STRUCTURAL PERMIT CORRECTIONS

May 5, 2022

RE Permit corrections for Koneru Residence at 6610 E Mercer Way, Mercer Island, WA 98040, Permit No. 2112-250

We have received and reviewed the STRUCTURAL comments regarding the 6610 E Mercer Way project, permit number 2112-250. Below are the corresponding responses to the structural comments for the correction notice prepared by Crystal Kolke, Kolke Consulting Group, Inc dated April 12, 2022:

OPEN RISER STAIR - UPPER SECTION  
SCALE: 3/4" = 1'-0"

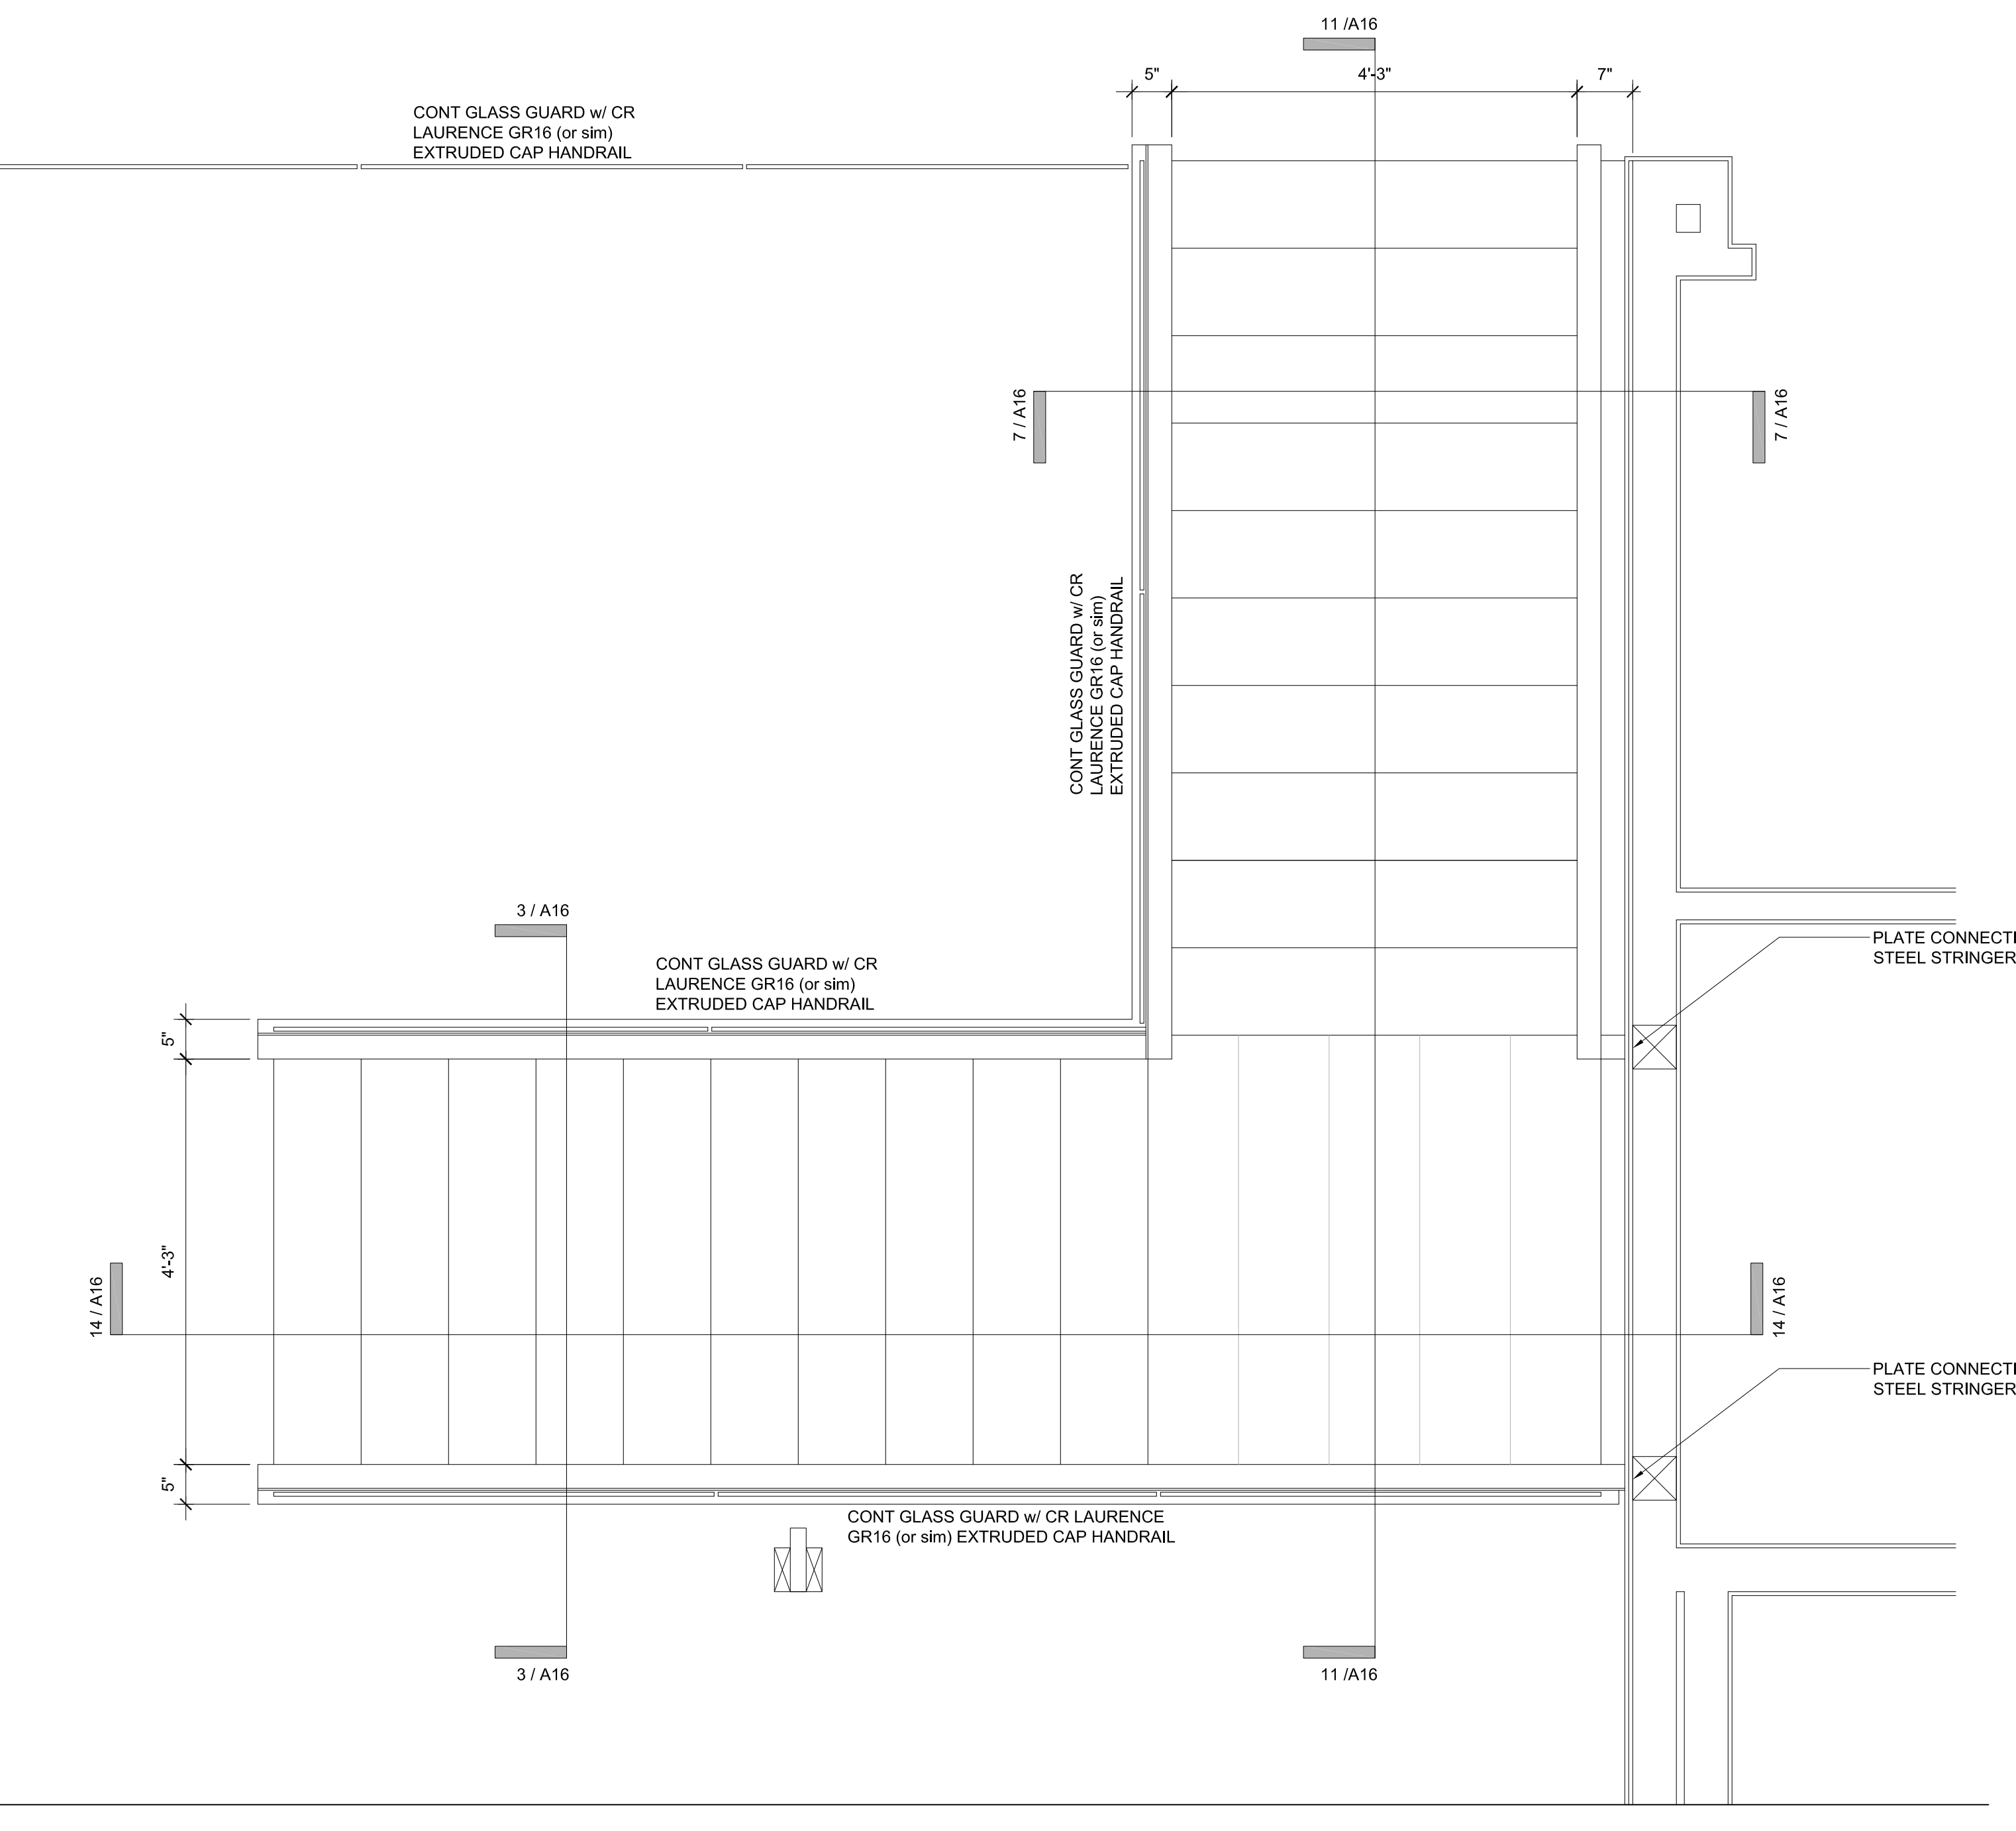
11. Stair and bridge connection details are shown on sheet A16. Bridge joists to beam welding connection has now been called out on plan sheet A6, and also typical bridge guardrail post required connection has now been called out on 13/S5.1.
